Submission – Objections and Recommendations to SSD-78669234 “Residential flat building with in-fill affordable housing – 27-29 Tryon Road, Lindfield”

I, **Peter Cheung of Unit 5, 9 Tryon Road**, make this submission **objecting** to State-significant development application **SSD-78669234** for a 7- to 9-storey residential flat building at 27-29 Tryon Road, Lindfield.

SHADOW DIAGRAMS - AMENDED SCHEME VS.PREVIOUS DA SCHEME

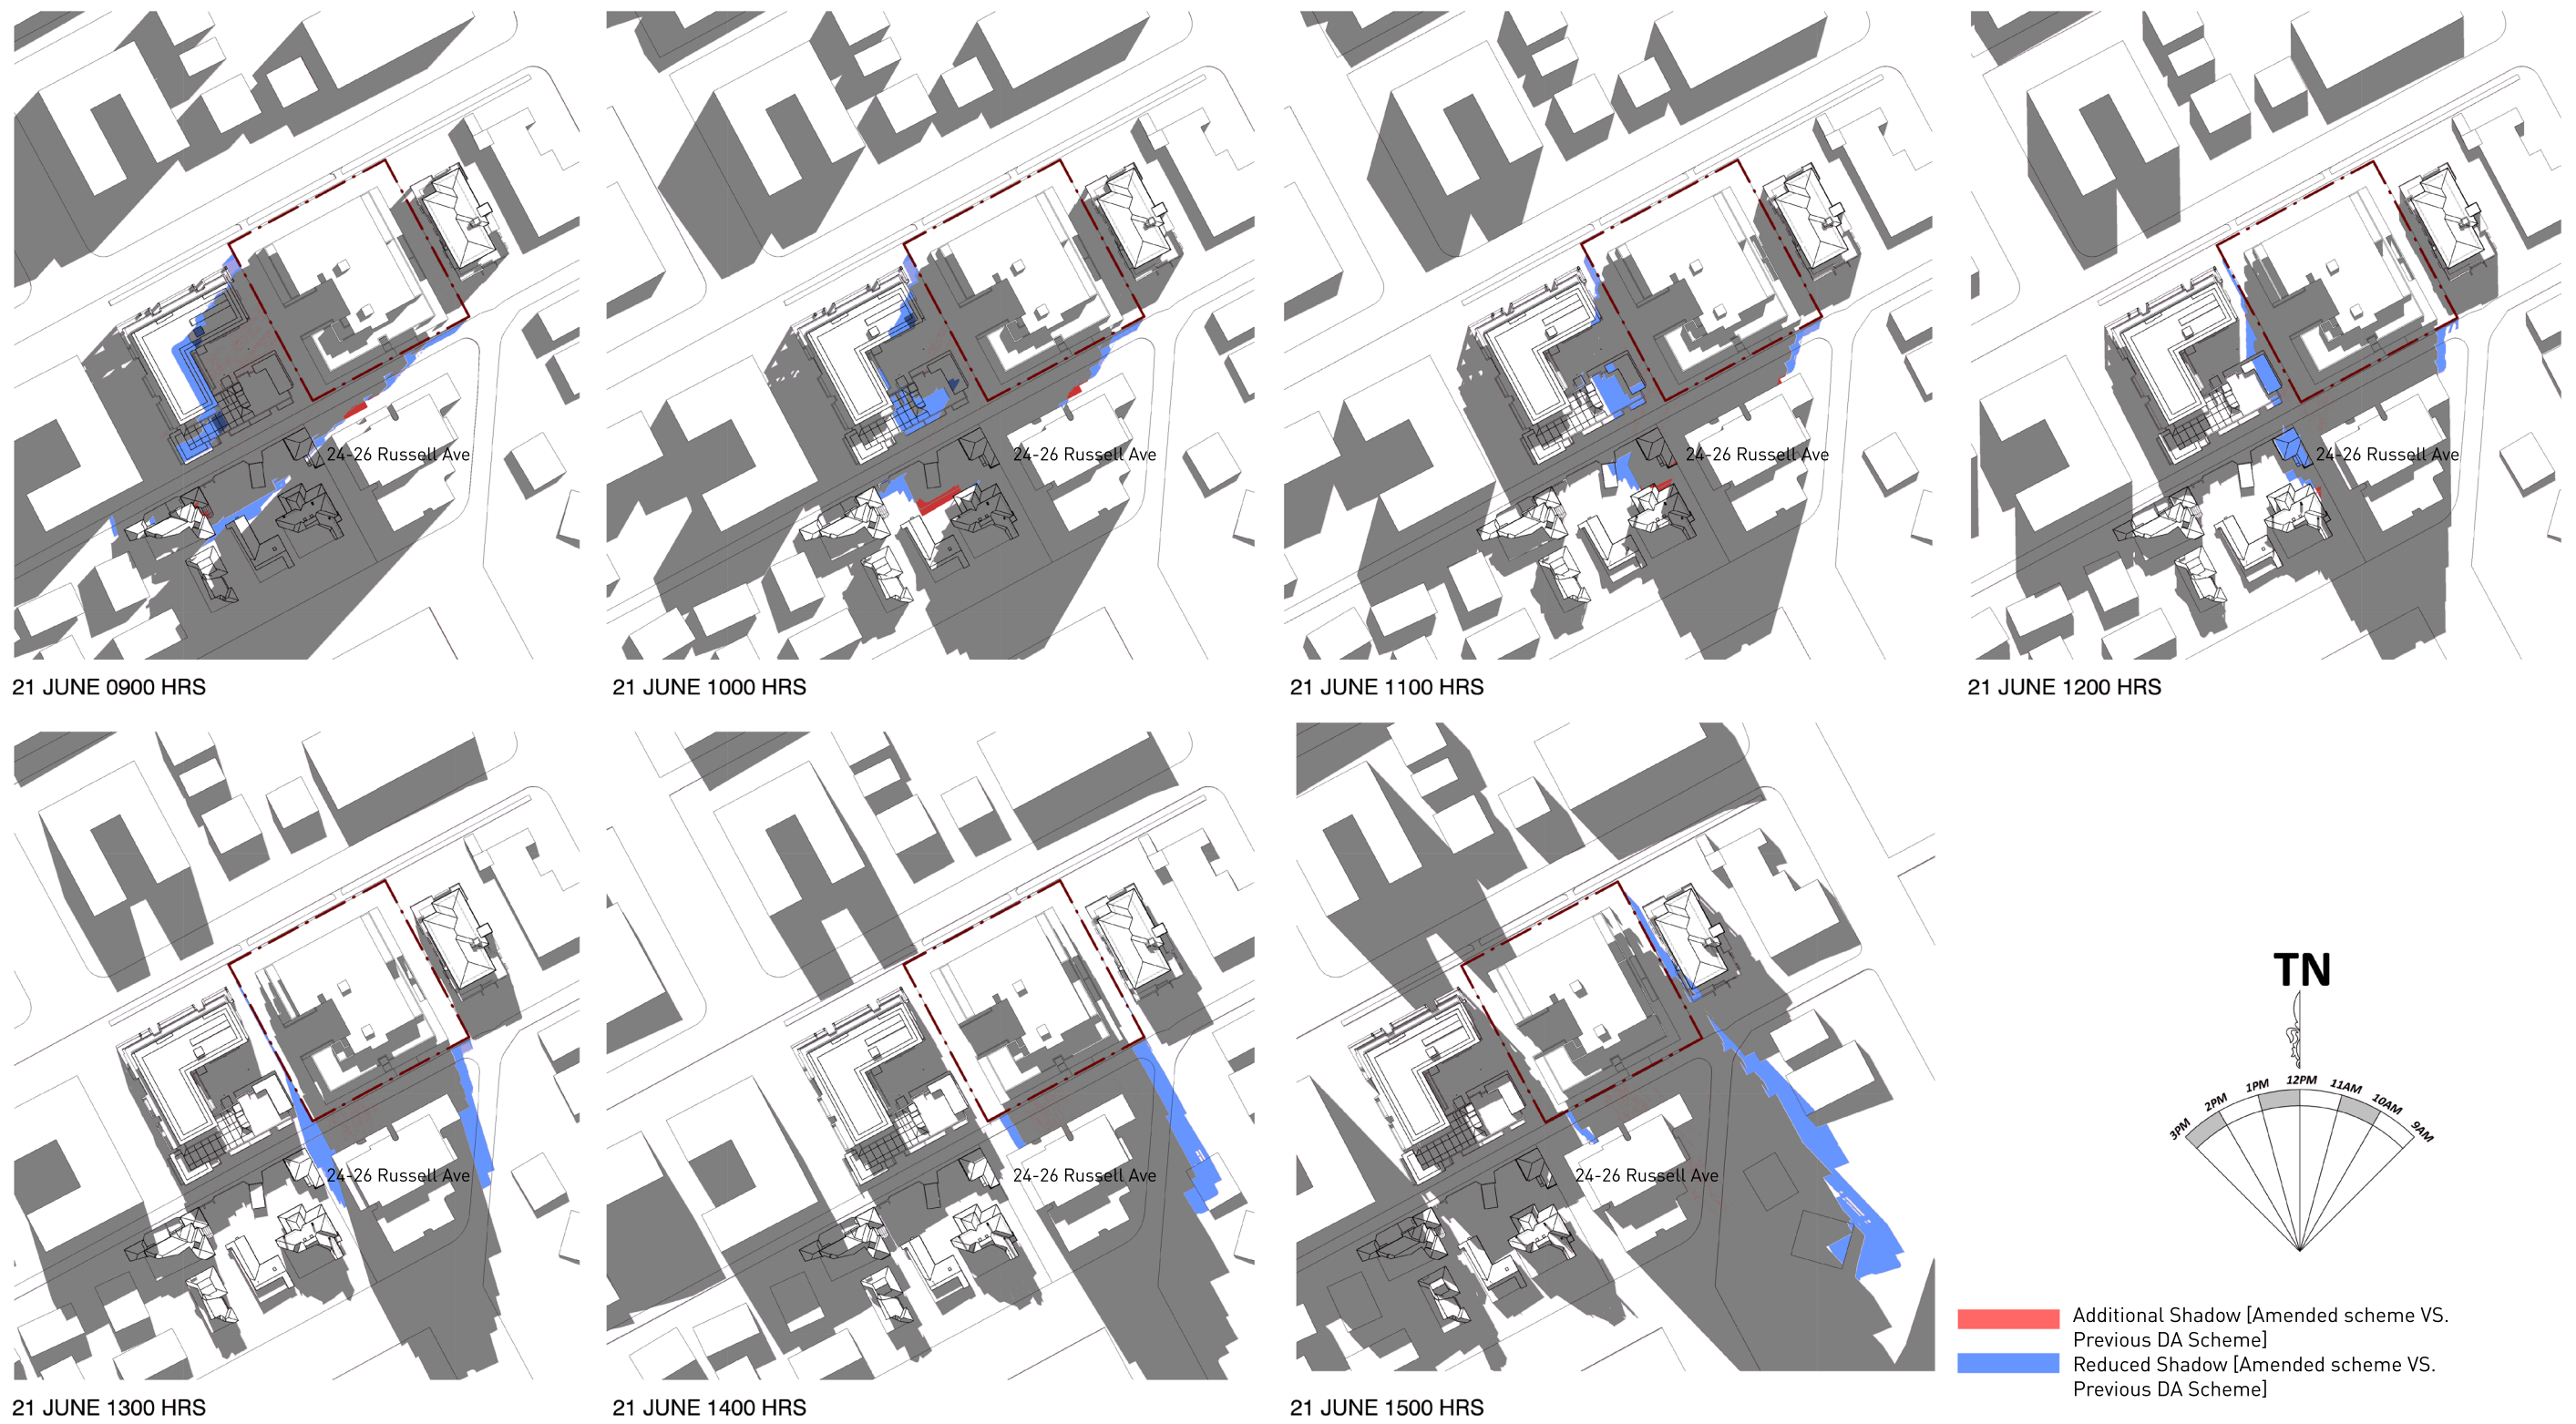
Shadow diagrams (winter solstice) show sunlight to Nos 25 & 31 dropping below the ADG two-hour minimum before 11 a.m., and the proposed roof garden atop Building C would directly overlook private courtyards. The combined envelope/roof-deck changes requested above would restore sunlight and privacy without compromising development yield unduly.

B. Over-shadowing & privacy loss	Winter shadows reduce sunlight to Nos 25 & 31 below 2-h ADG benchmark; roof garden directly overlooks neighbours.	Adopt 5-storey envelope; relocate or delete roof garden (if retained, restrict use to 7 a.m.–9 p.m. and install screening).
